SUBJECT: Engineering Review Comment
Mountain View Electric Association Inc. (MVEA)

Project Name: Rolling Hills Ranch North Filing 2 – Final Plat

Project Number: SF2424

TRACT A  
39.841 AC.

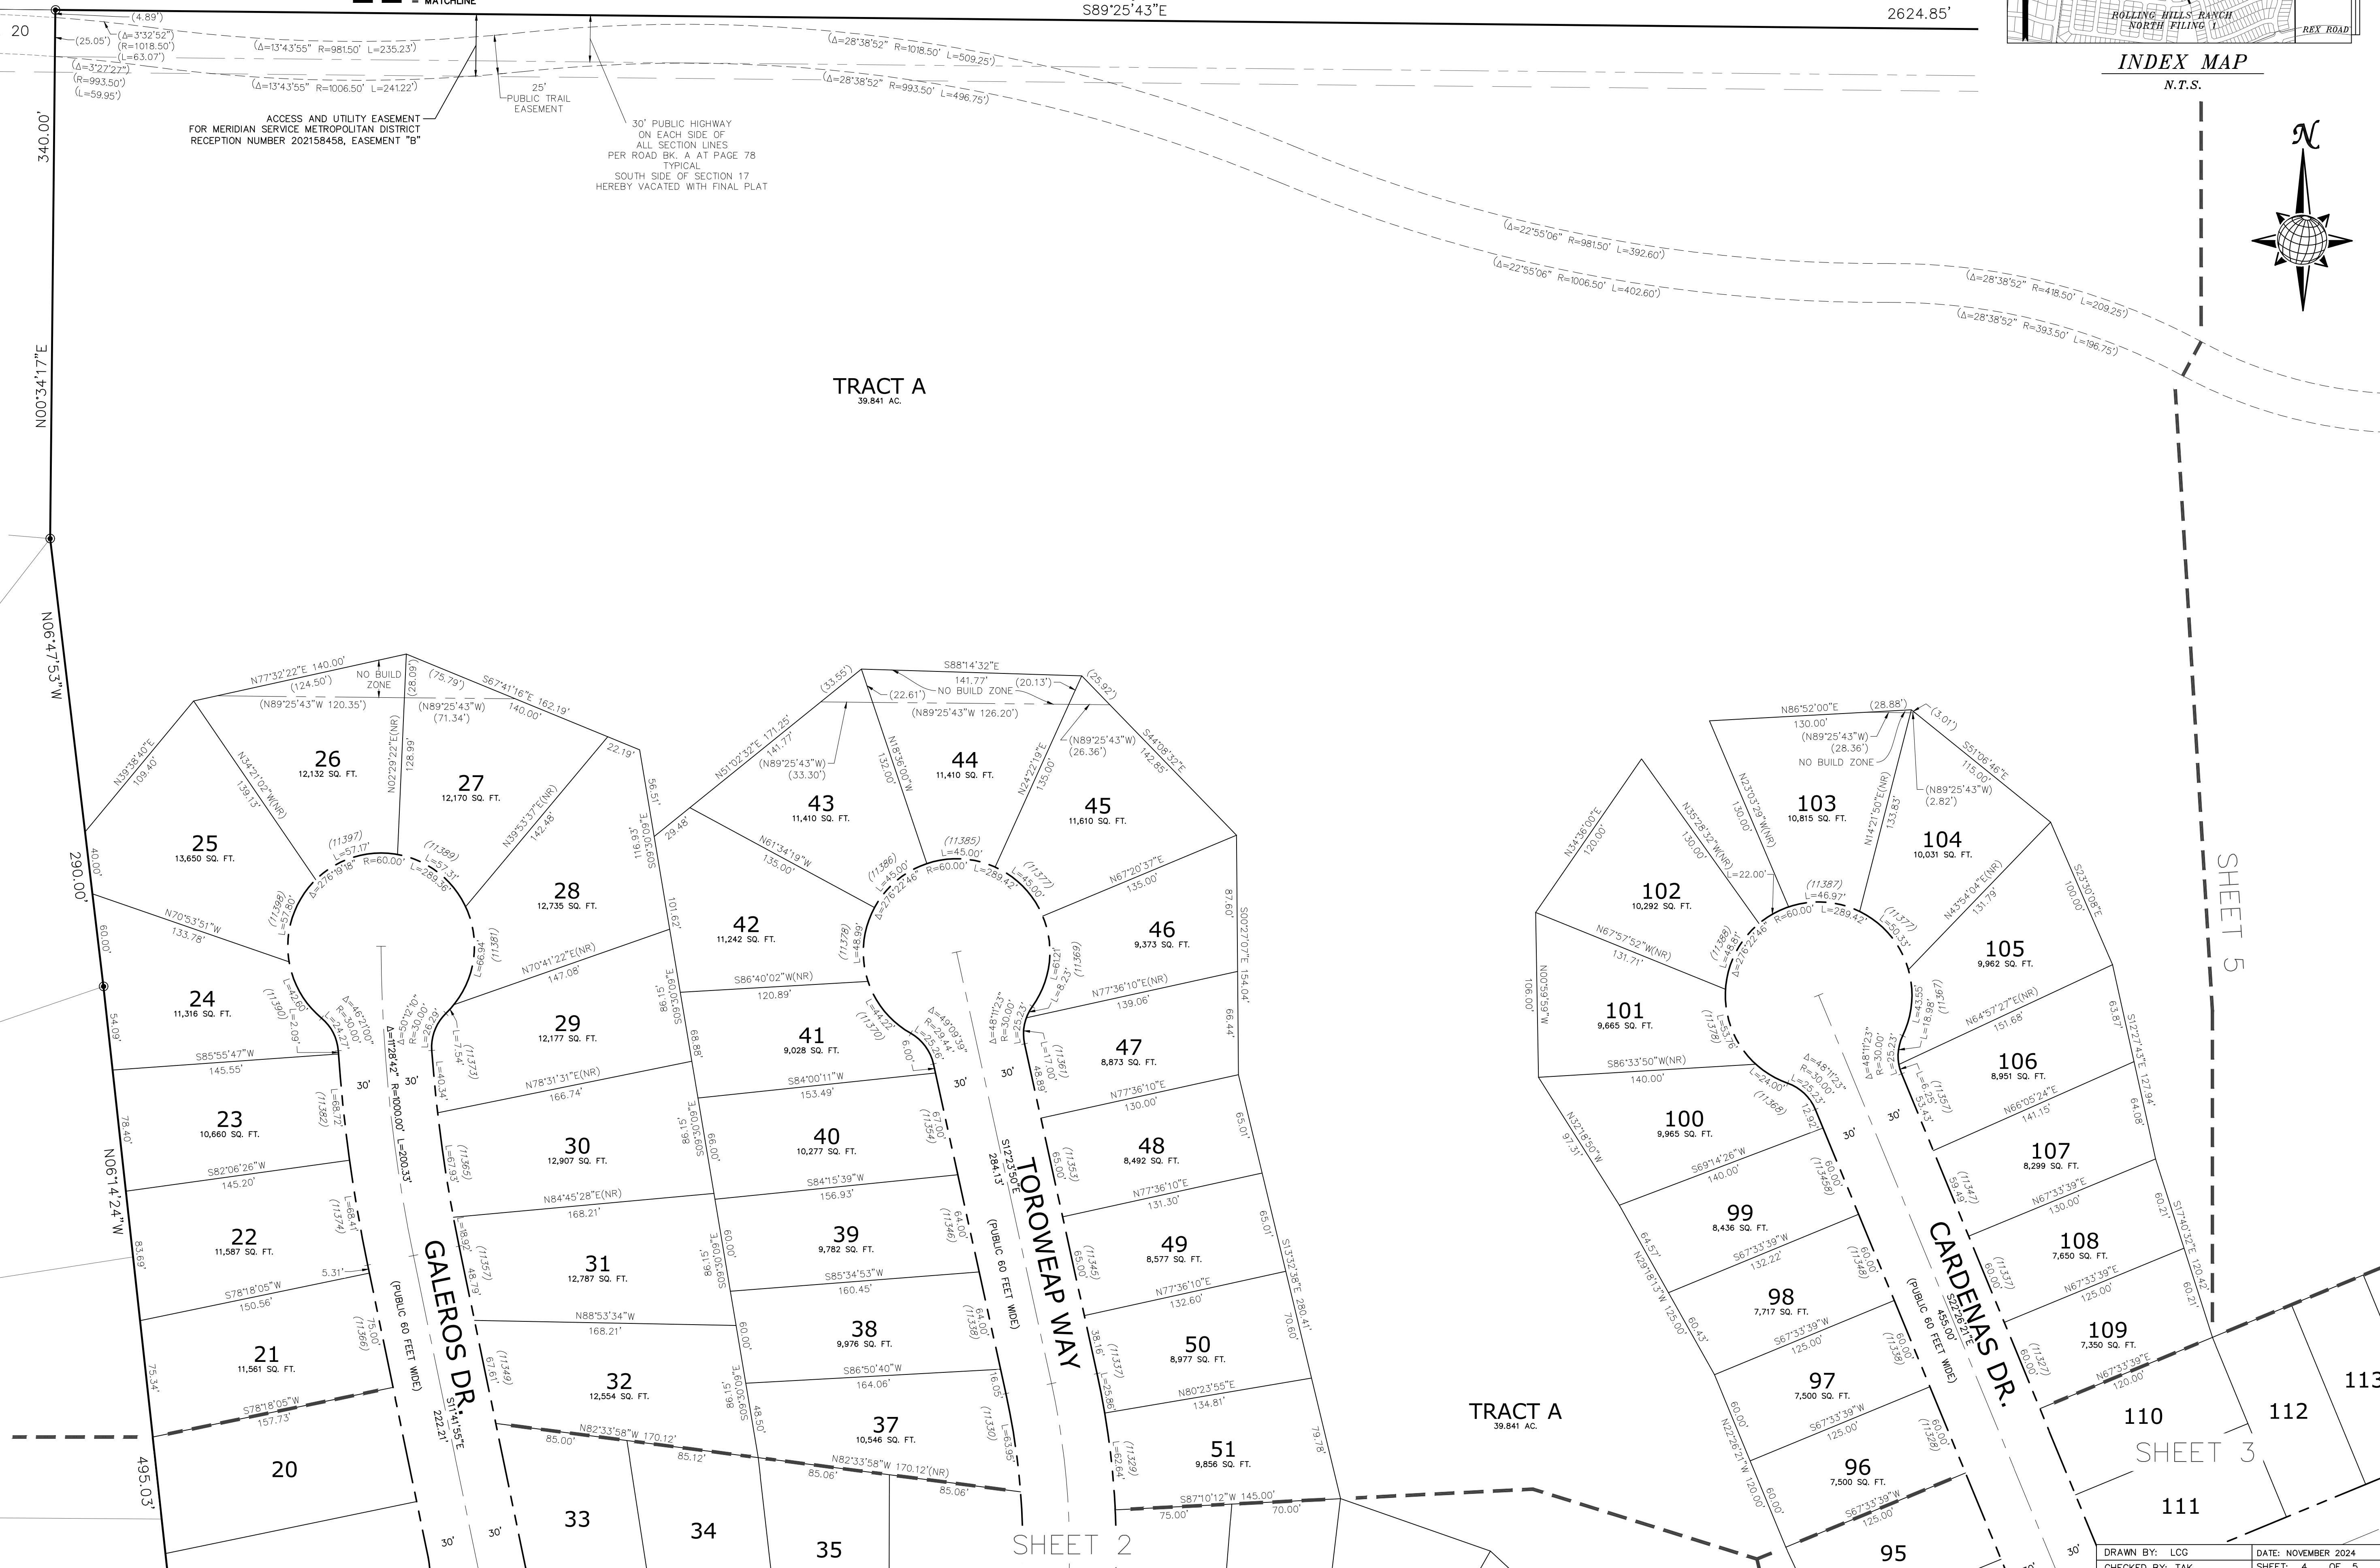
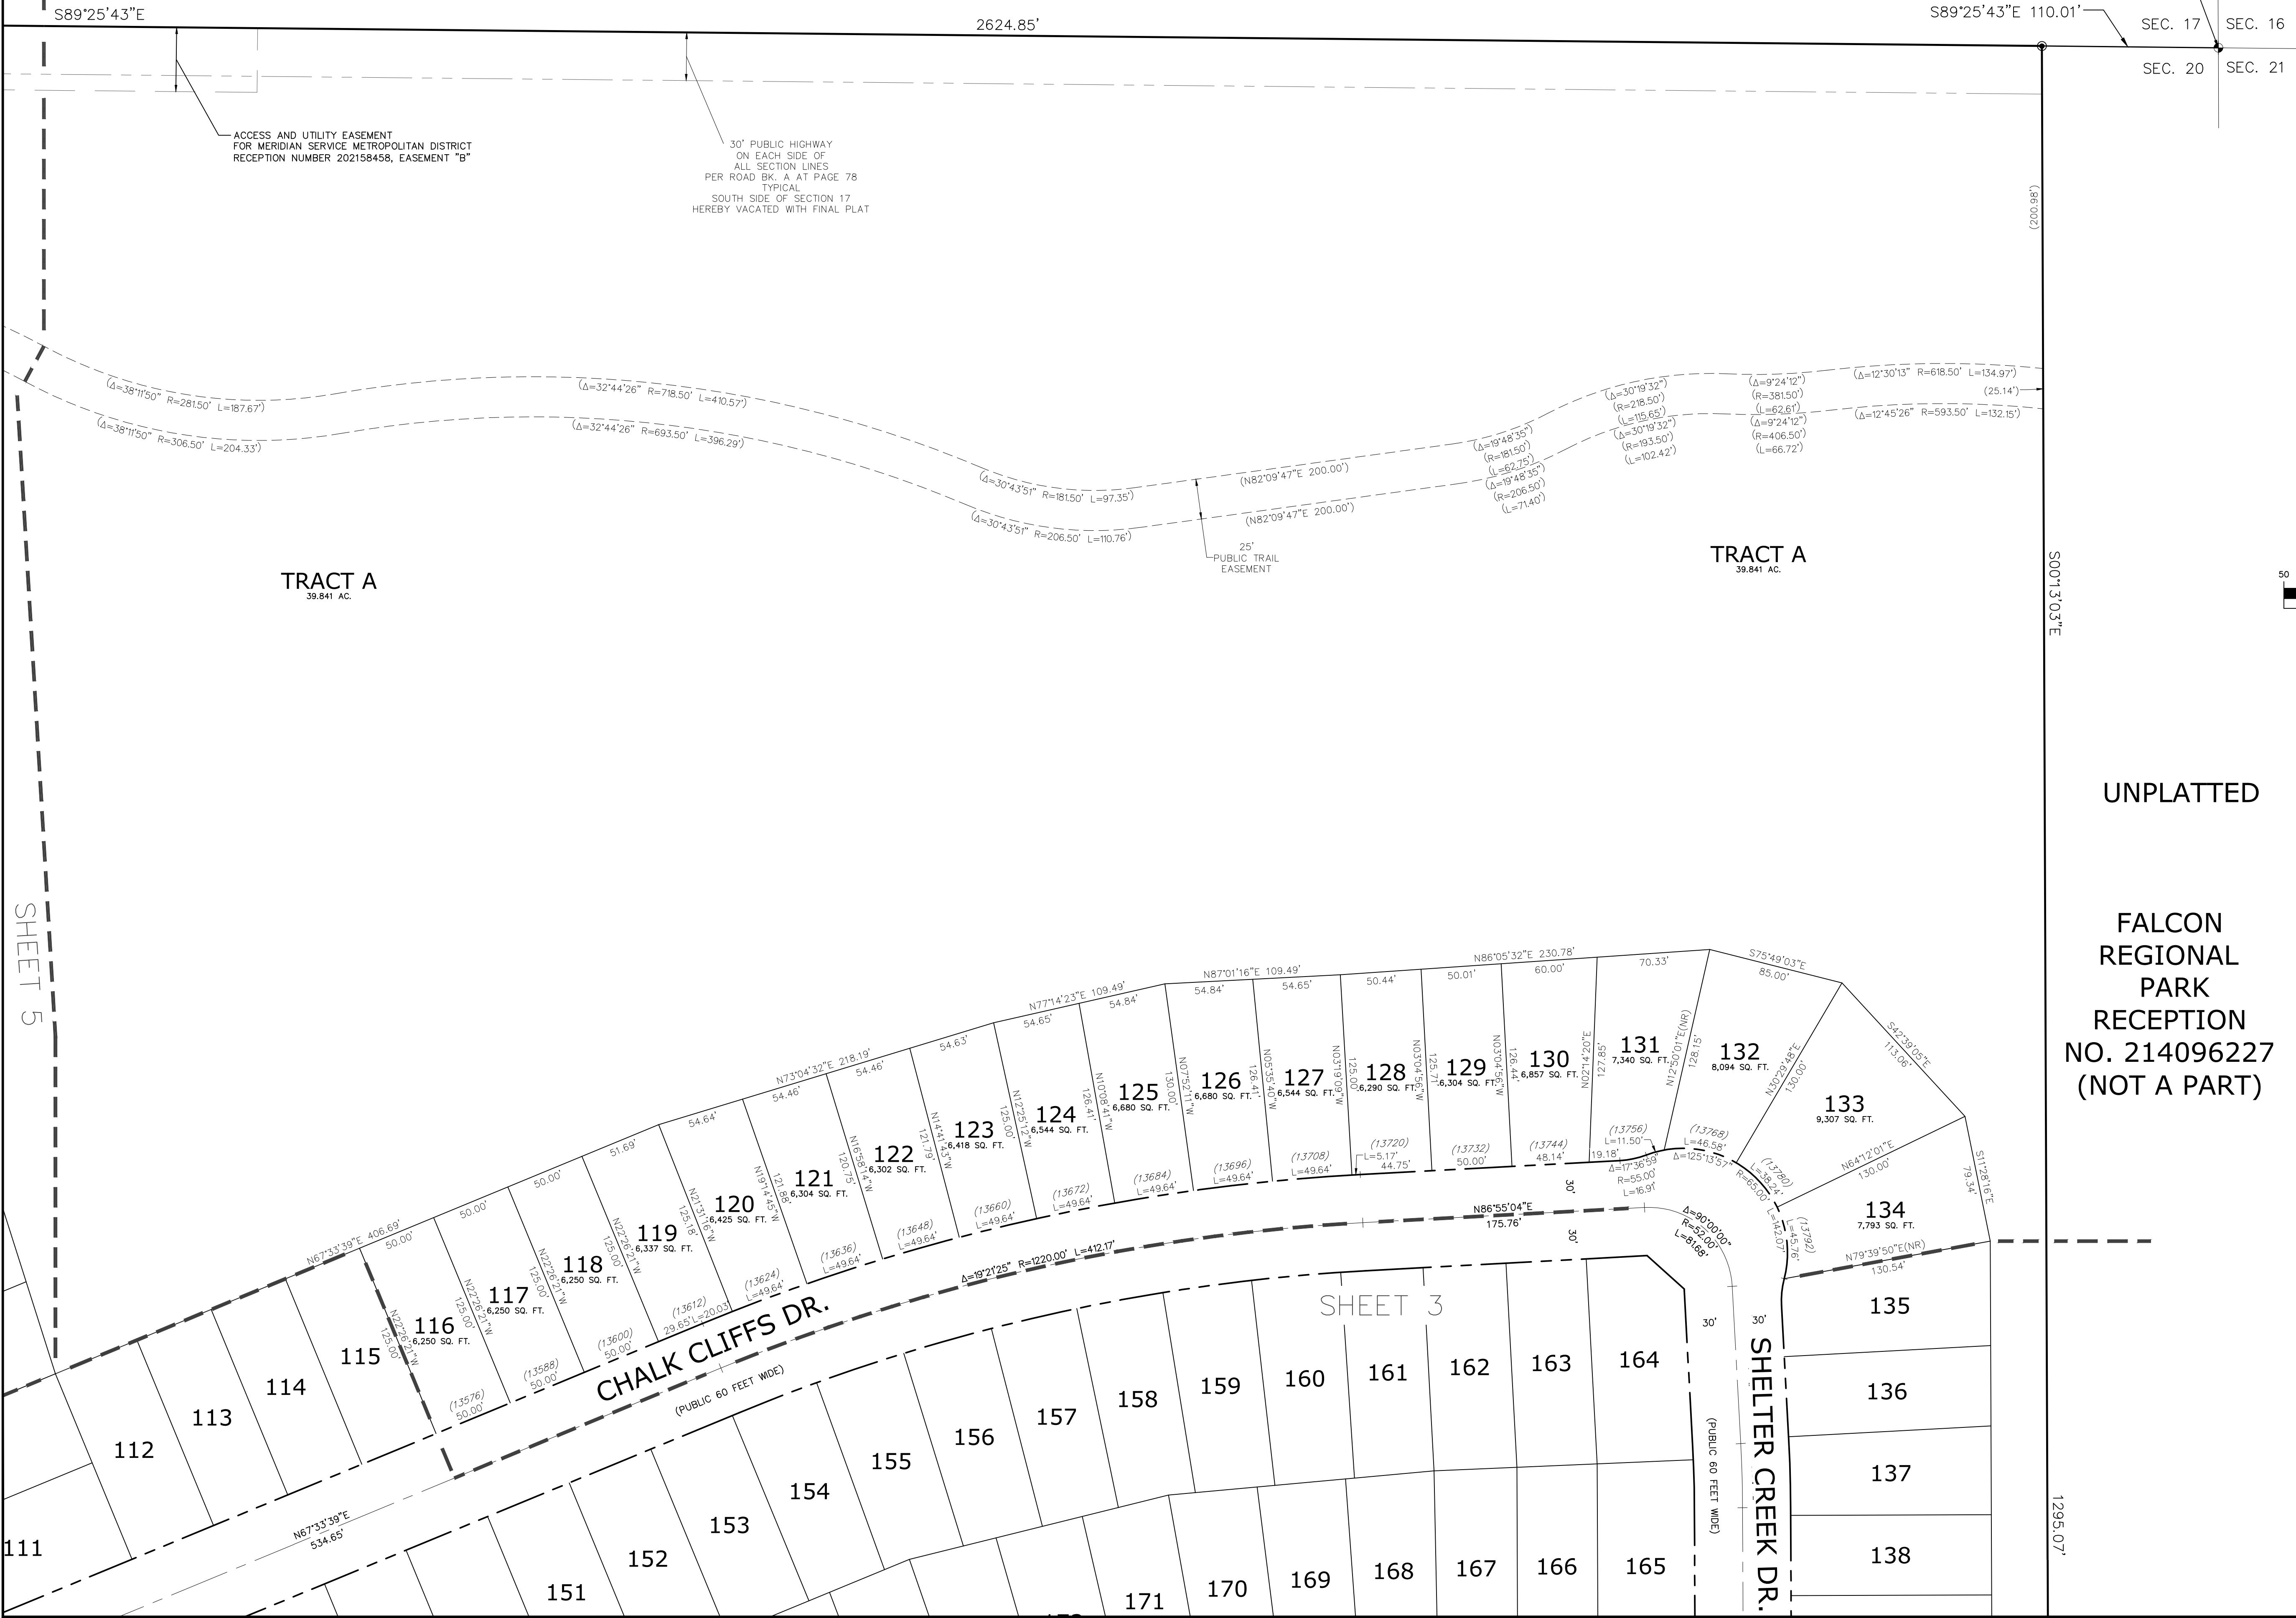
MVEA requests a ten (10) foot front lot utility easement, a five (5) foot side lot utility easement, and a seven and a half (7.5) foot rear lot utility easement along with a twenty (20) foot exterior utility easement on the plat and all tracts include easements. MVEA also requests the platting of MVEA's existing facilities with easements on the plat. Additional easements may be required.

MVEA has existing facilities near and within this parcel of land. If there is any damage, removal or relocation of facilities it will be at the expense of the applicant.
